Road Safety Audit Response Report

Report title:	Proposed Residential Access, Yapton Lane, Walberton
Date:	March 2022
Document reference and revision:	RSA-022-005-1
Prepared by:	JBAudits
On behalf of:	Bellamy Roberts

The scheme is a new single priority T-junction off Yapton Lane, Walberton, that is proposed to serve a residential development of some 50 dwellings.

Extract of drawing 5478/002 Rev F

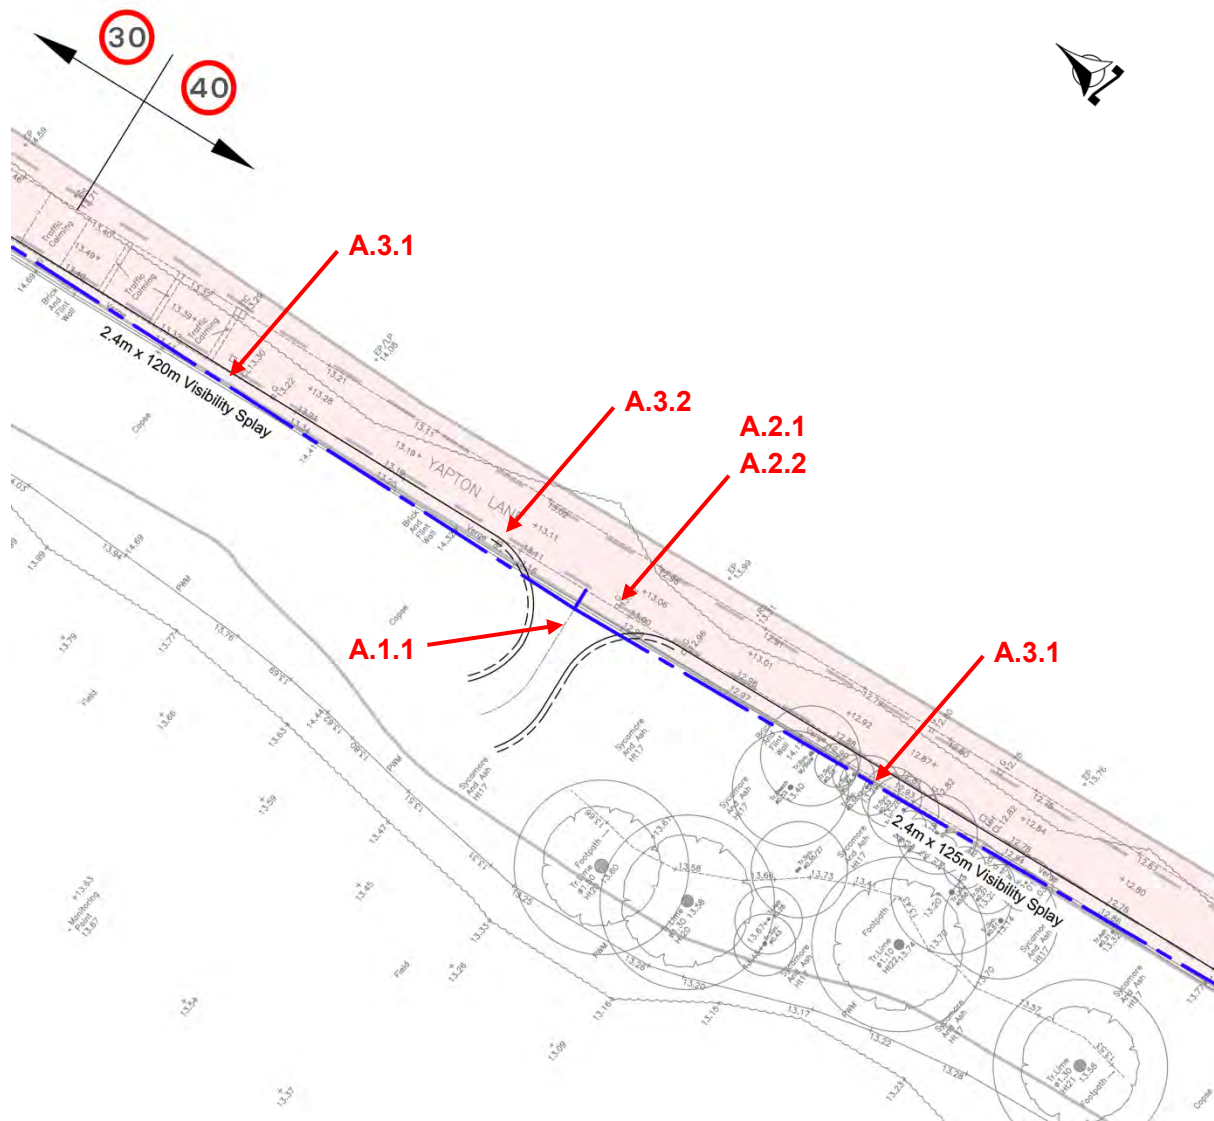
RSA Problem	RSA Recommendation	Design Organisation Response	Overseeing Organisation Response	Agreed RSA Action
Refuse Vehicle conflict with other vehicles at access.	It is recommended that the geometry of the proposed access is sufficient to allow a refuse / recycling collection vehicle to enter and exit whilst opposed by a car.	Agreed.		
Existing road gully situated within path of vulnerable road users.	It is recommended that the existing gully is relocated.	Agreed.		
Existing road gully is blocked with debris.	It is recommended that the existing gullies along Yapton Lane are cleared of debris.	Agreed. Although is a matter for WSCC maintenance team.		
Inadequate horizontal visibility.	It is recommended that the brick and flint wall is relocated behind the visibility splay.	Agreed.
